## **SSD 6471 - Sydney Modern, Art Gallery of NSW, Sydney**

This submission concerns the Traffic Impact Assessment (TIA).

Figure 32: Art Gallery Road drop-off/pick-up – northern part

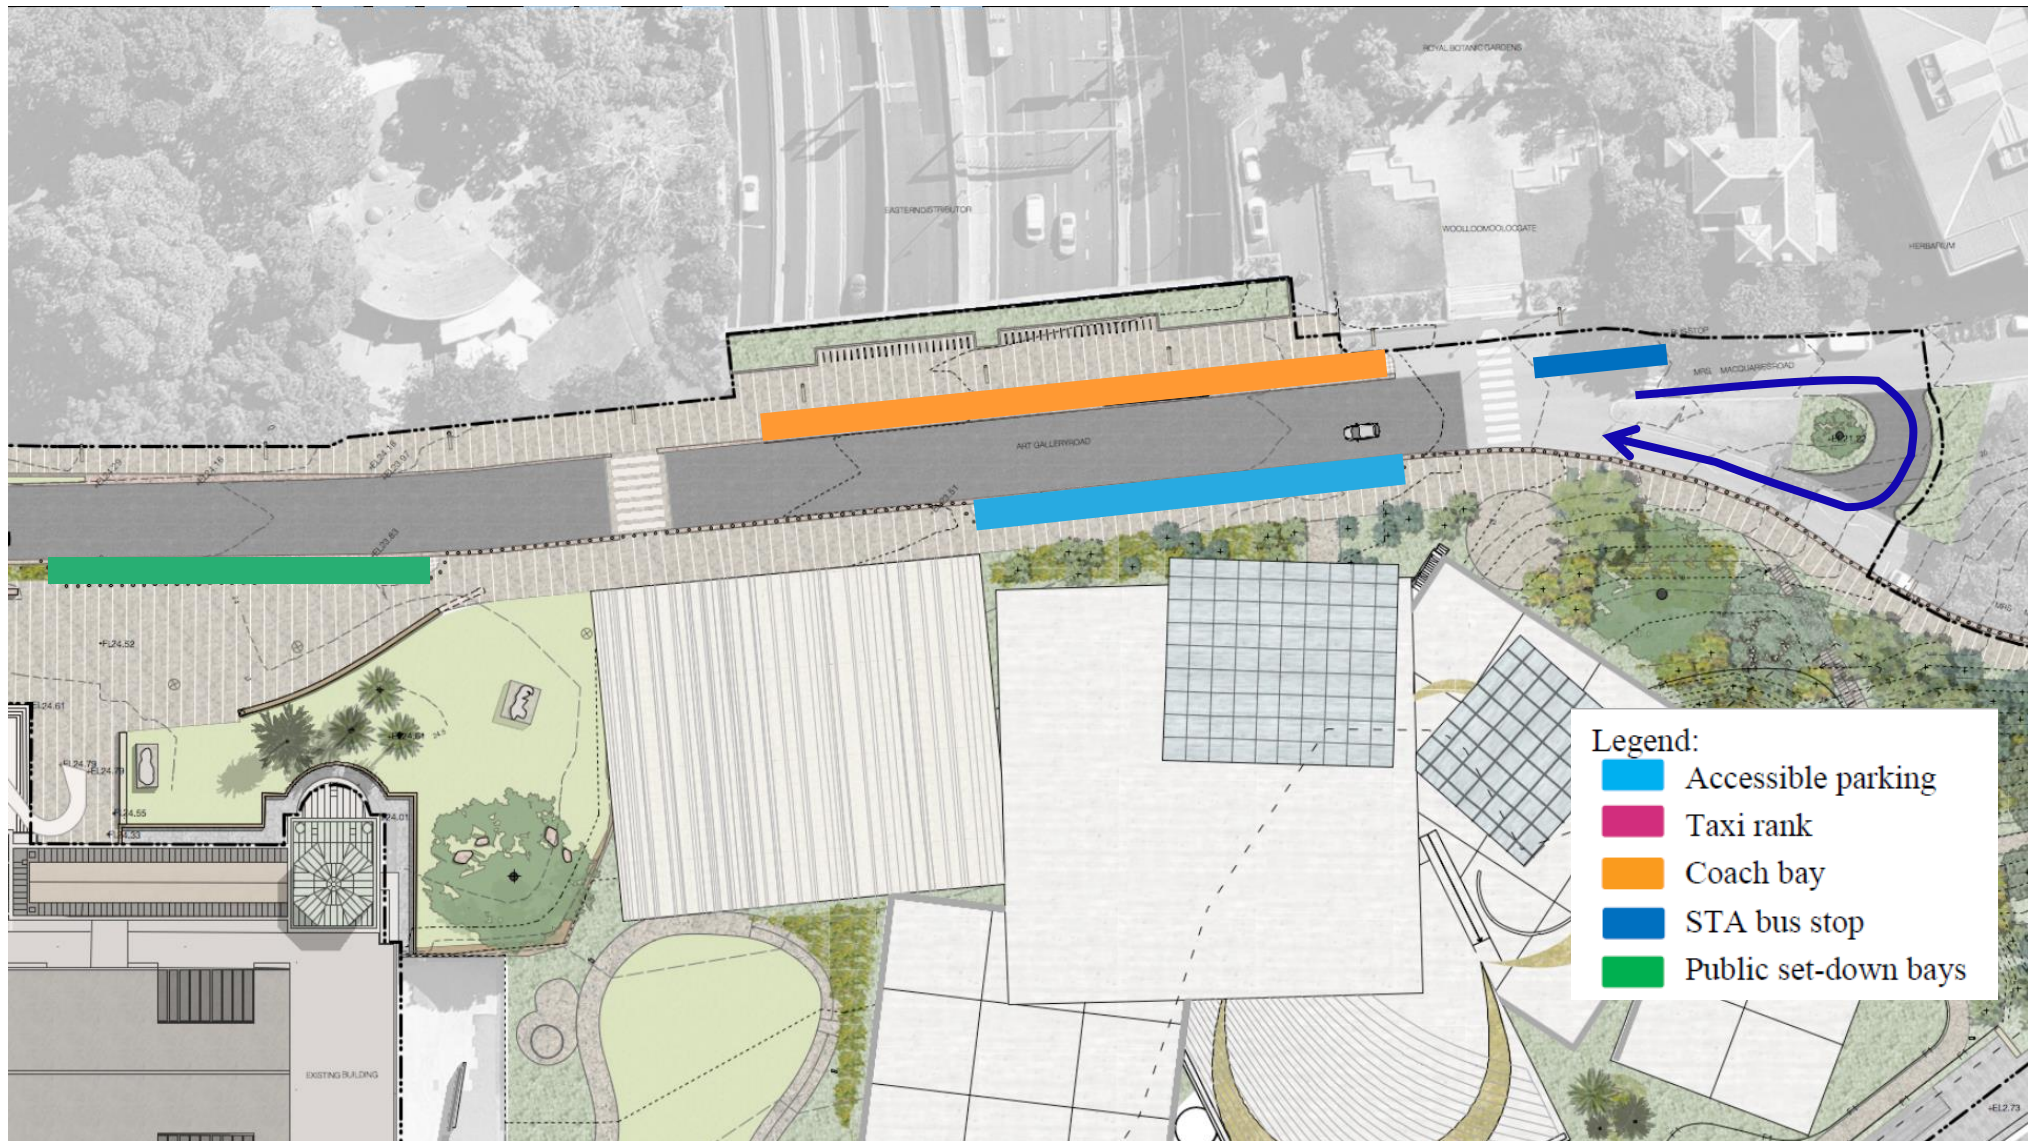
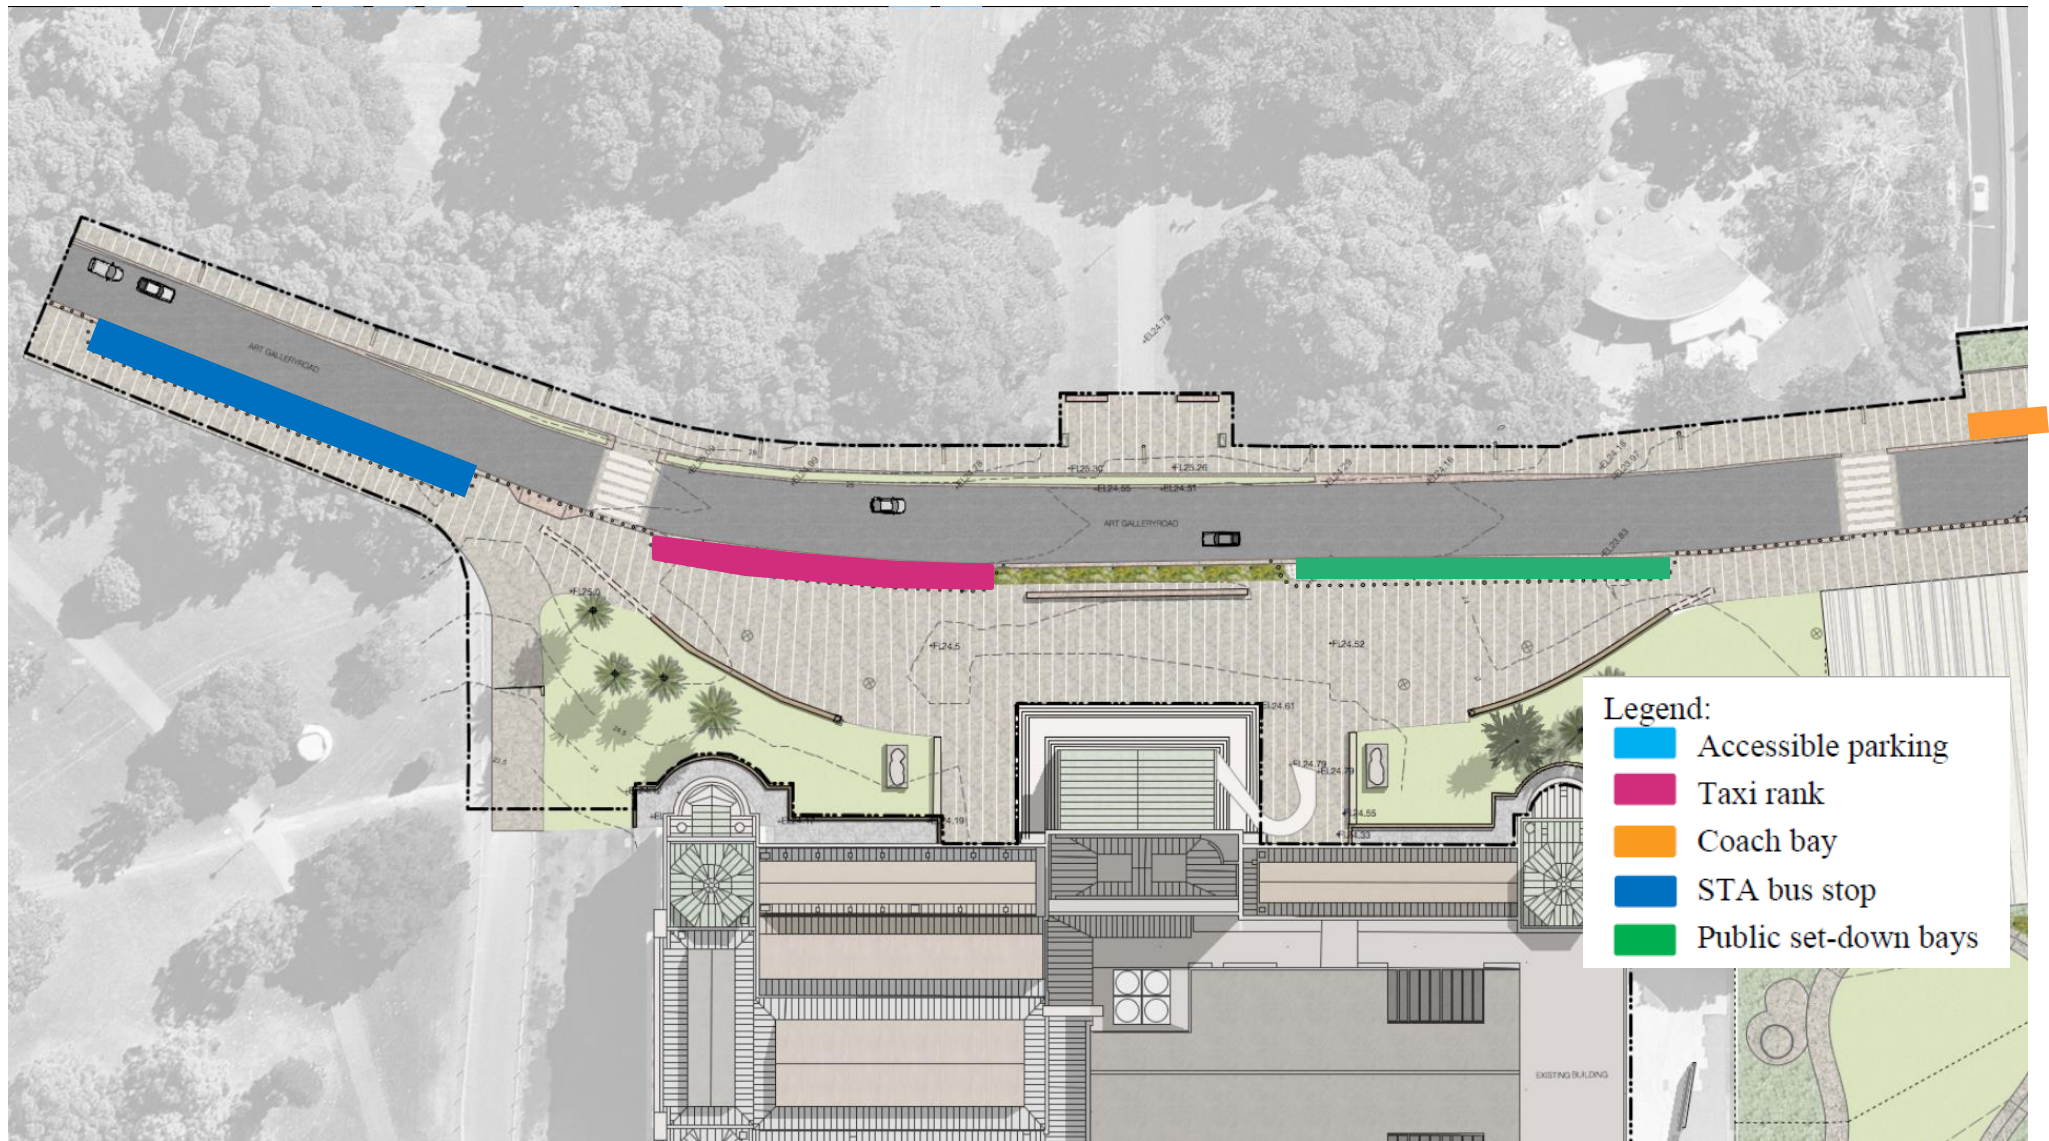
The current arrangements will need to be maintained whereby coaches depart the site and park remotely before returning for pick-up at the northern side of Art Gallery Road.

The TIA does not consider alternatives. The most obvious is to locate the coach drop-off/pick-up on St Mary's Road. This would eliminate the intrusion of the coaches into the park environment. If it is OK for visitors arriving by train to walk for 10 minutes to reach the AGNSW, it is surely OK for those arriving by coach to walk for 5 minutes.
